Application No: FP/175/20/HH
Site Address: 23 Thirlmere Way Felpham PO22 8NQ
Description of works: Single storey side & two-storey rear extension.

Thank you for your internet representation made on 20th October 2020 which has been recorded as an objection with the comments as follows:

Drawing Title:
PROPOSED PLANS AND ELEVATIONS

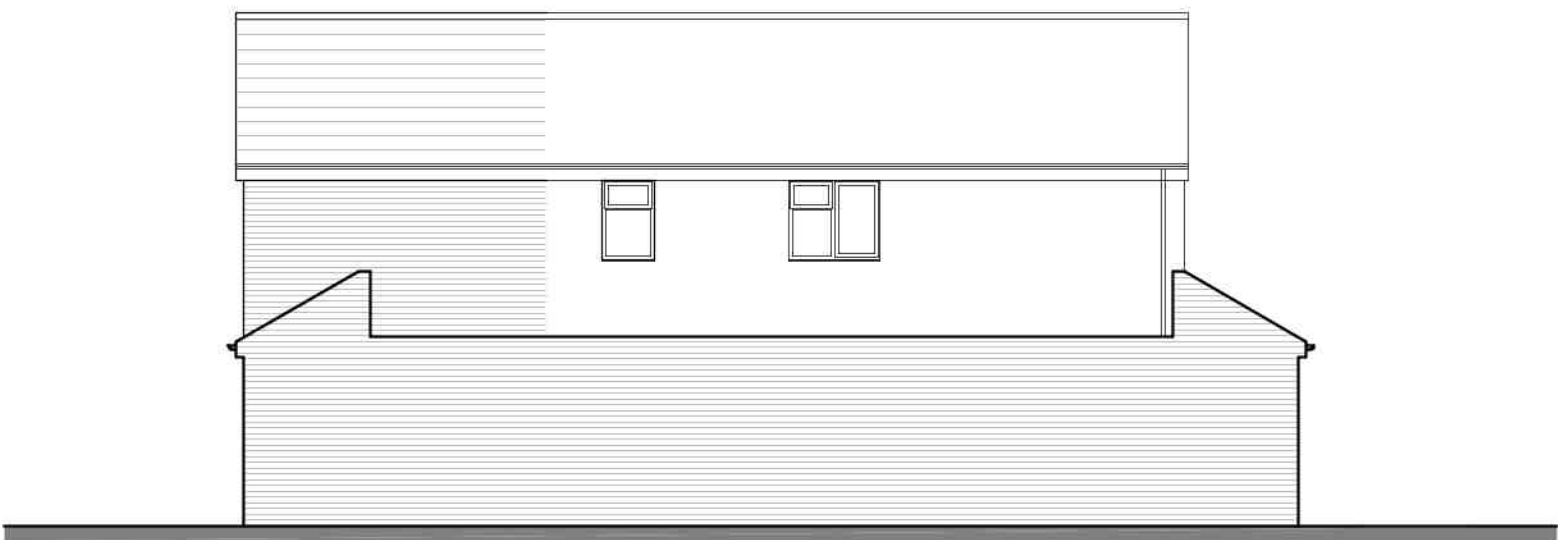
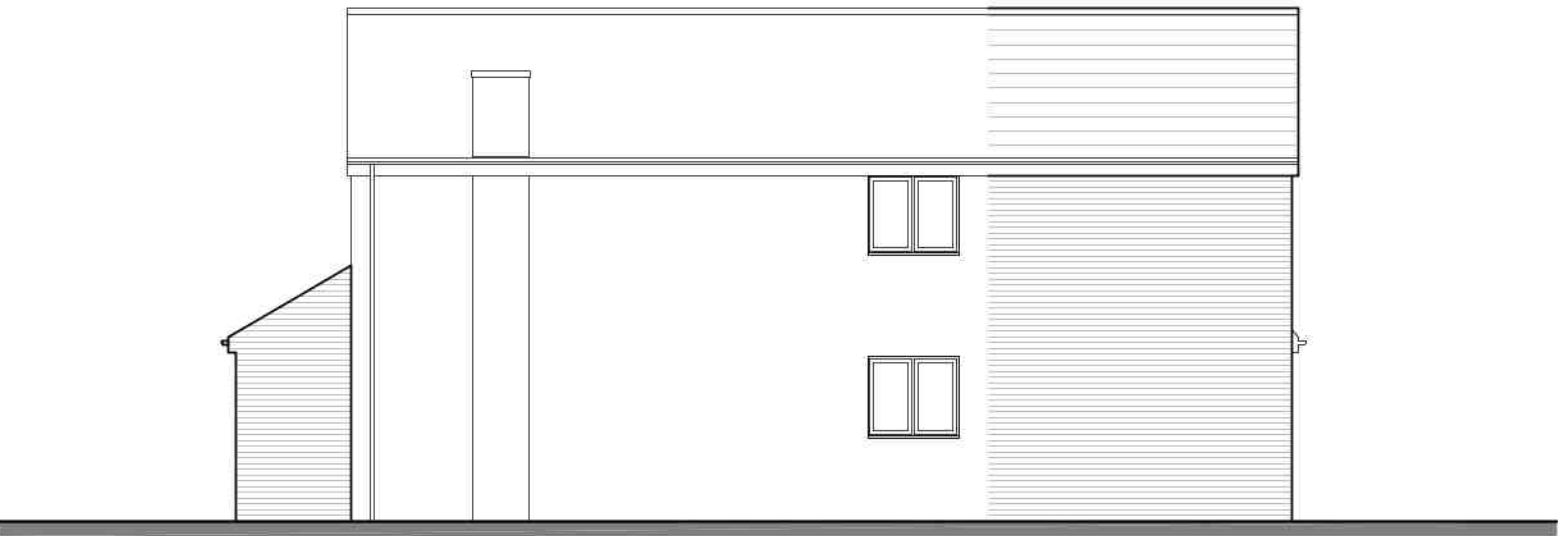
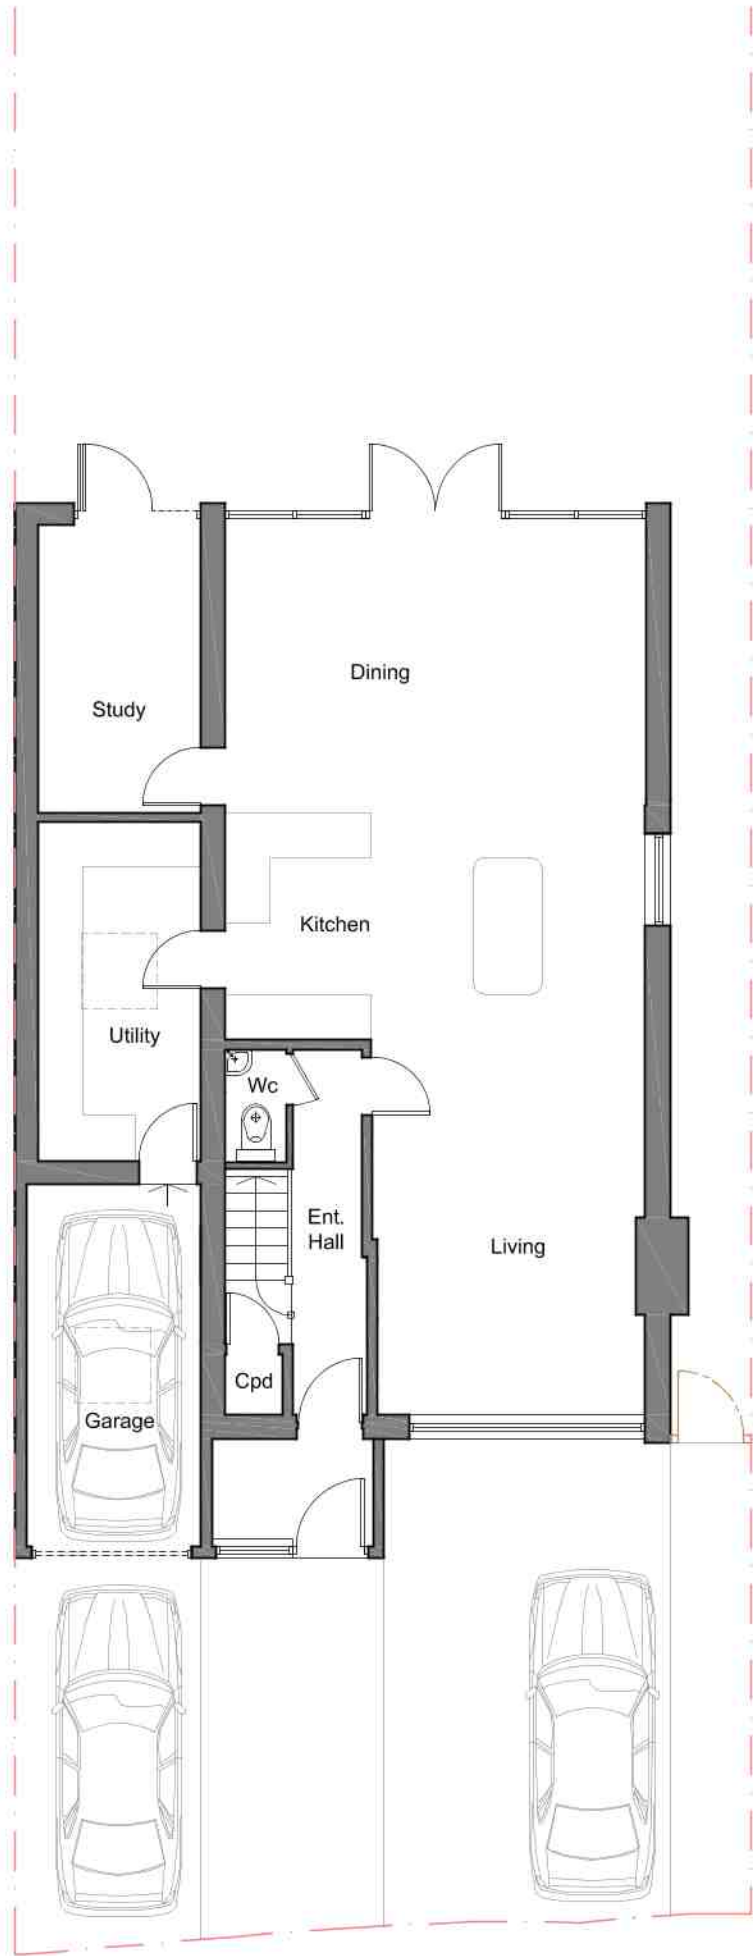
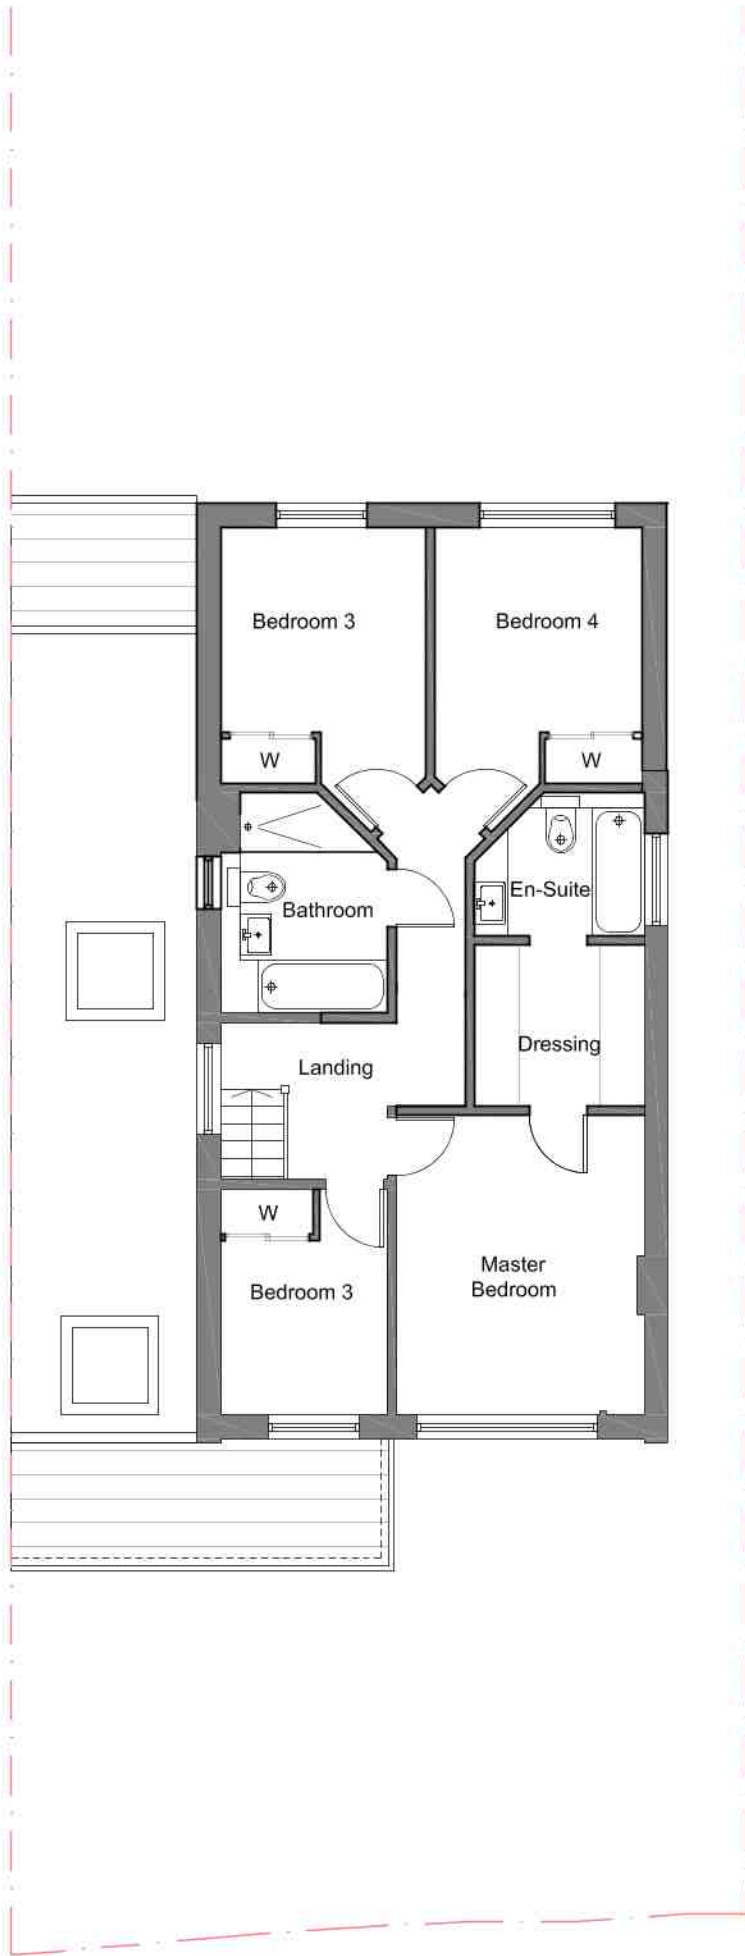
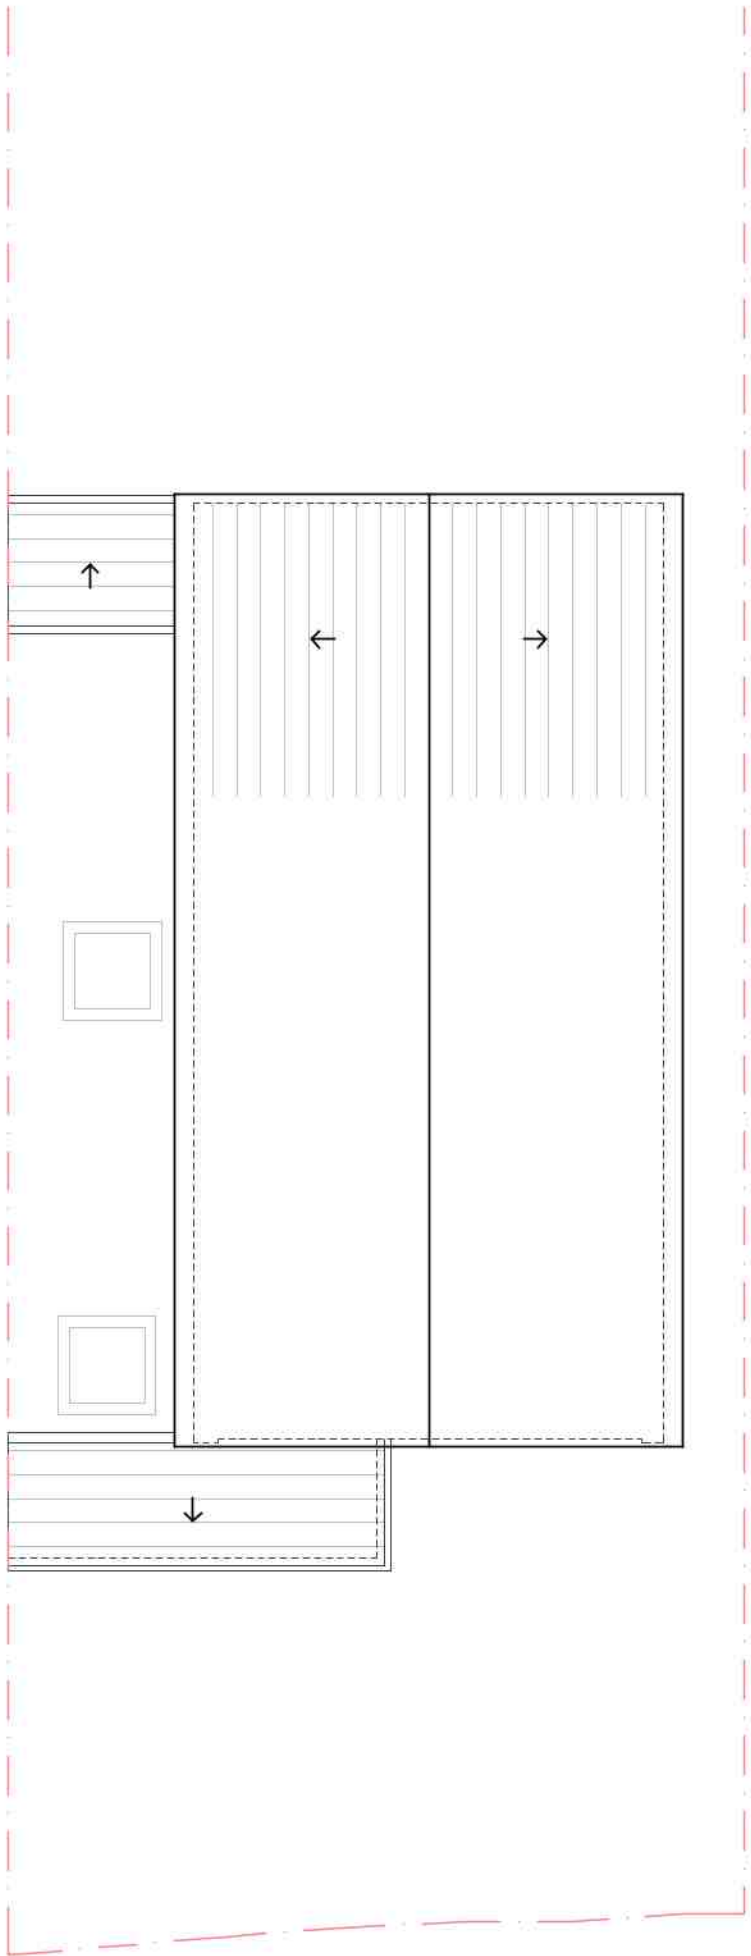
I object to the two windows on the northerly facing wall, the existing house has no windows giving me privacy into my property and garden, this is a massive selling point as it was to myself 20+ years ago this would change and devalue my property if this goes ahead.

The rear extension would block light from my garden and property and neighbouring properties.
